PLANNING AMENDMENT

H14/0491/97
15 JAN 1998

CHANGE OF USE FROM AGRICULTURE TO EQUESTRIAN CENTRE

Revisions to Access/Car park & future layout

scale	date	drawn
1: 500	OCT 97	NBS
project no.		drawing no
1405		AB/1

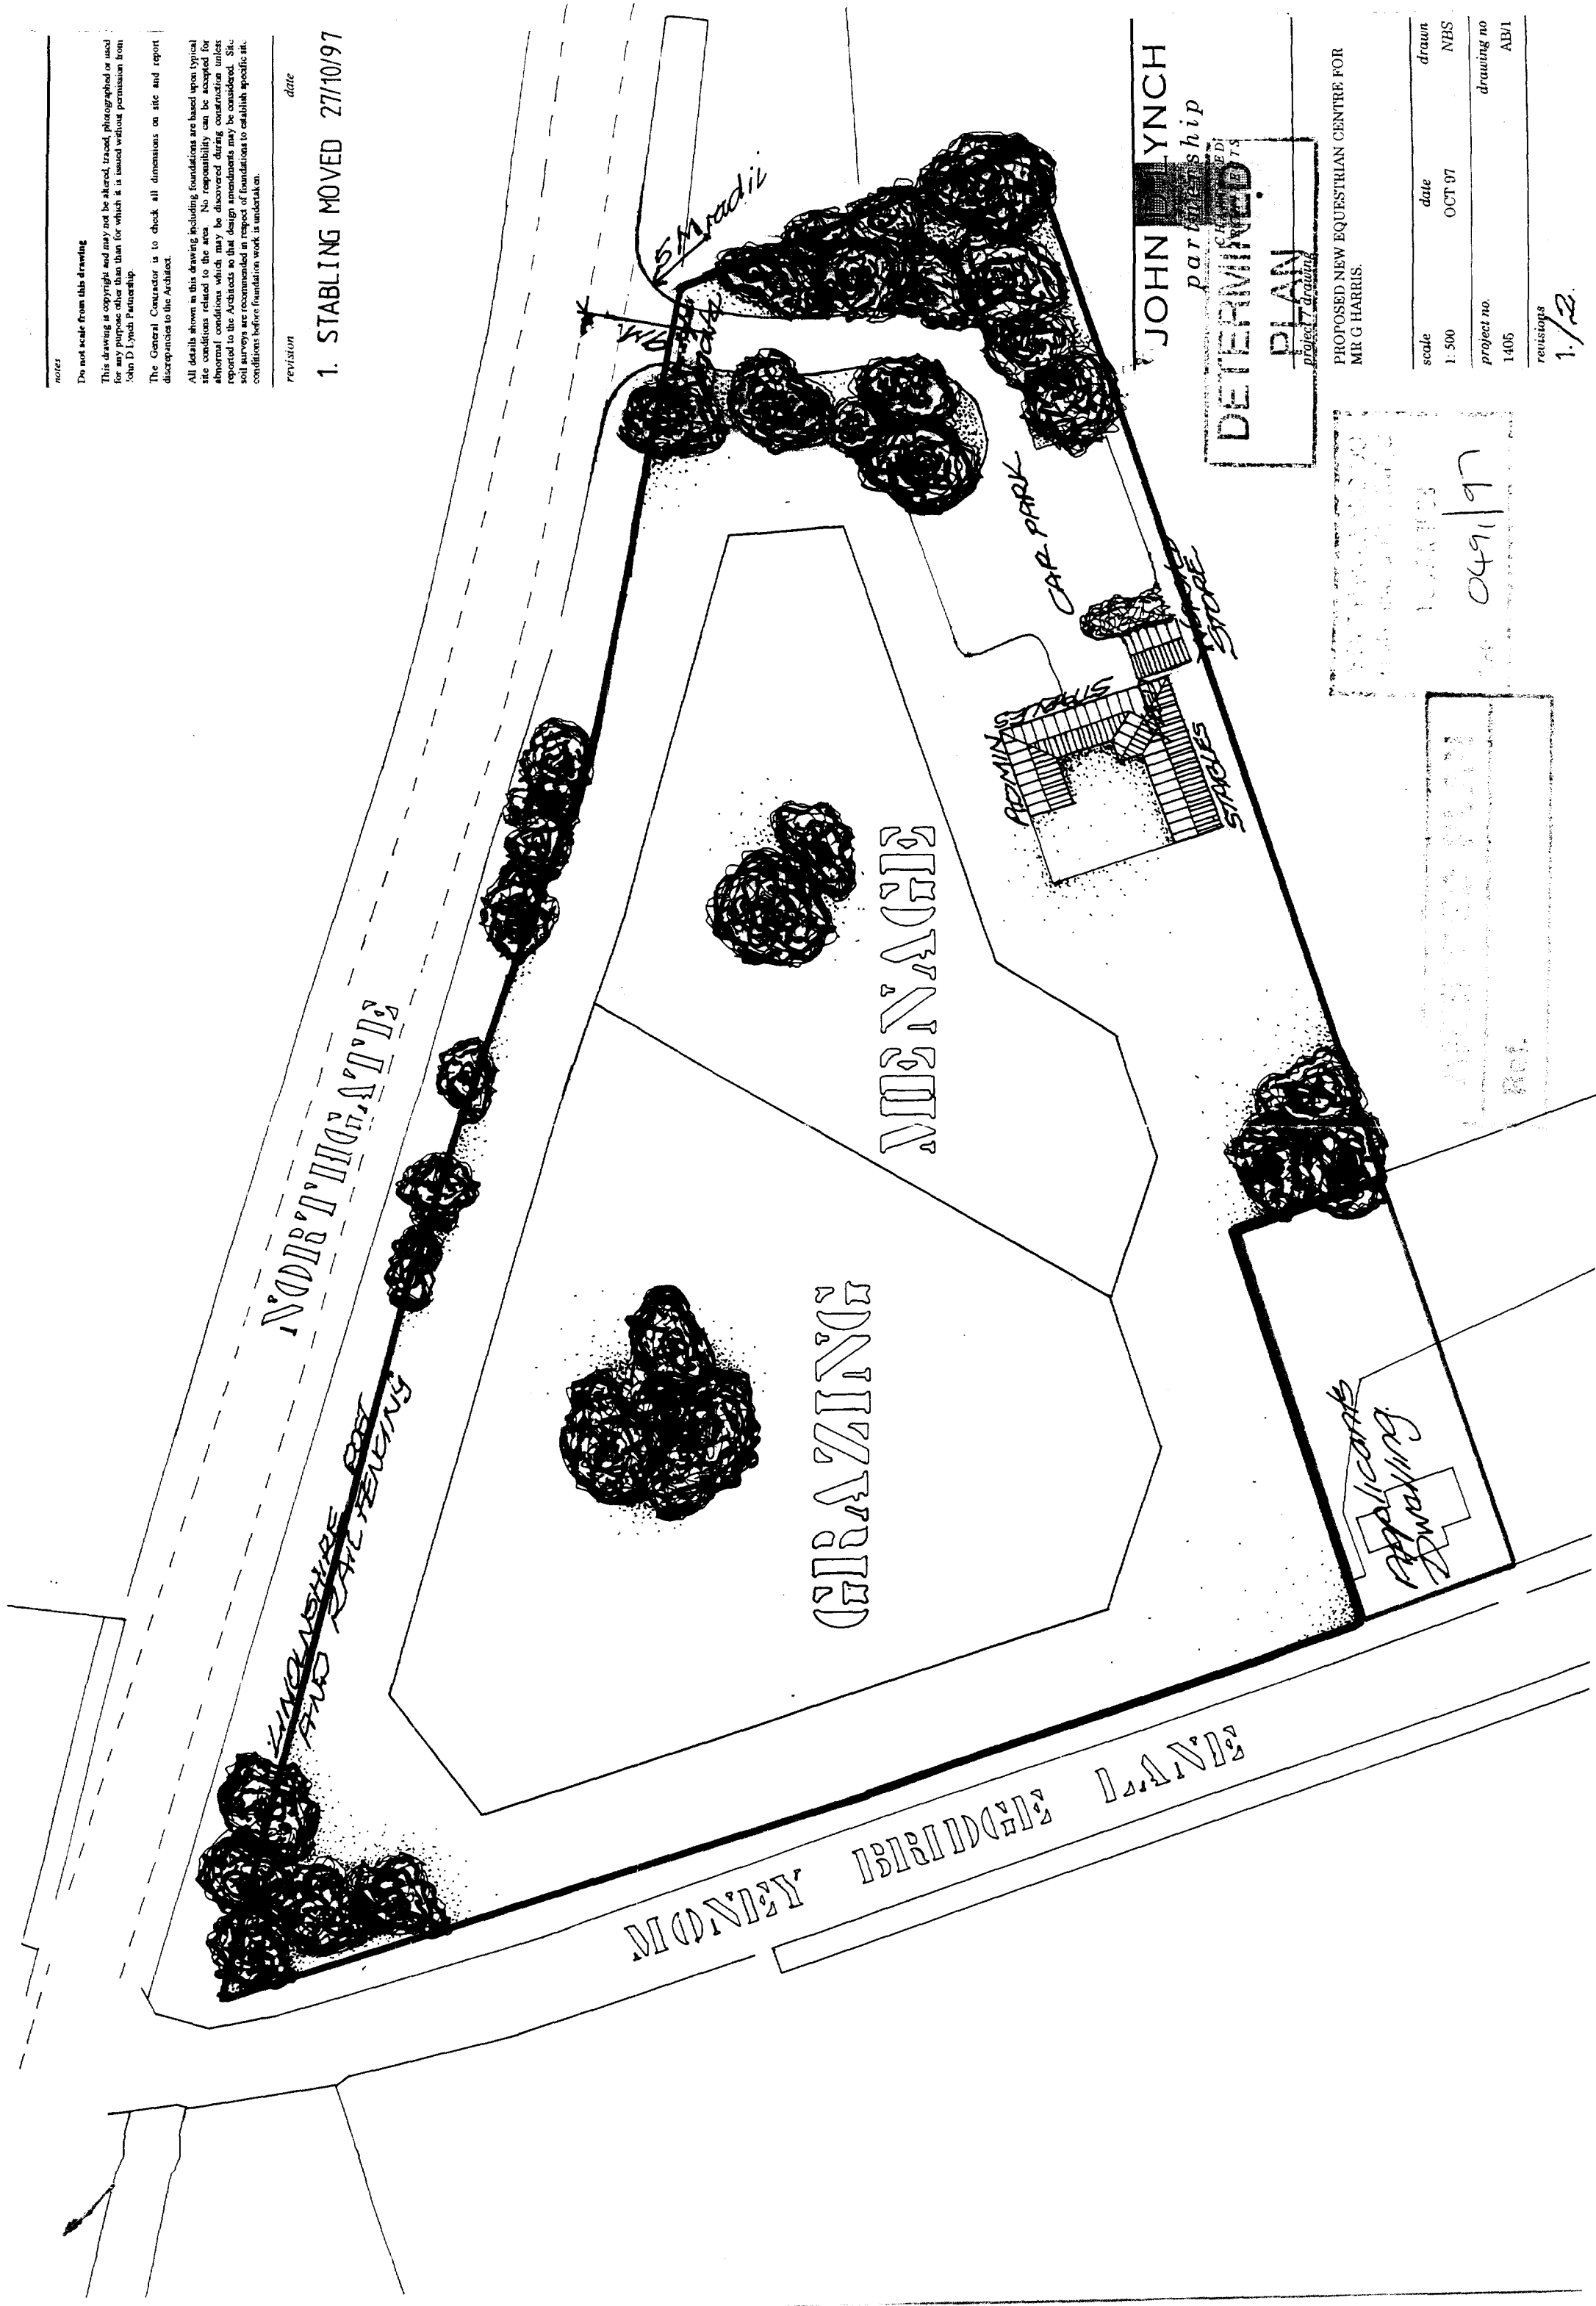
SECTION 106 OBLIGATION GRANTED. SITING OF BUILDINGS MOVED TO CENTRE POSITION ON SOUTH BOUNDARY. ACCESS ARRANGEMENTS TO NORTHGATE IMPROVED AND GATE POSITIONED. WASTE STORAGE BUILDING PROVIDED AND LOCATION IDENTIFIED
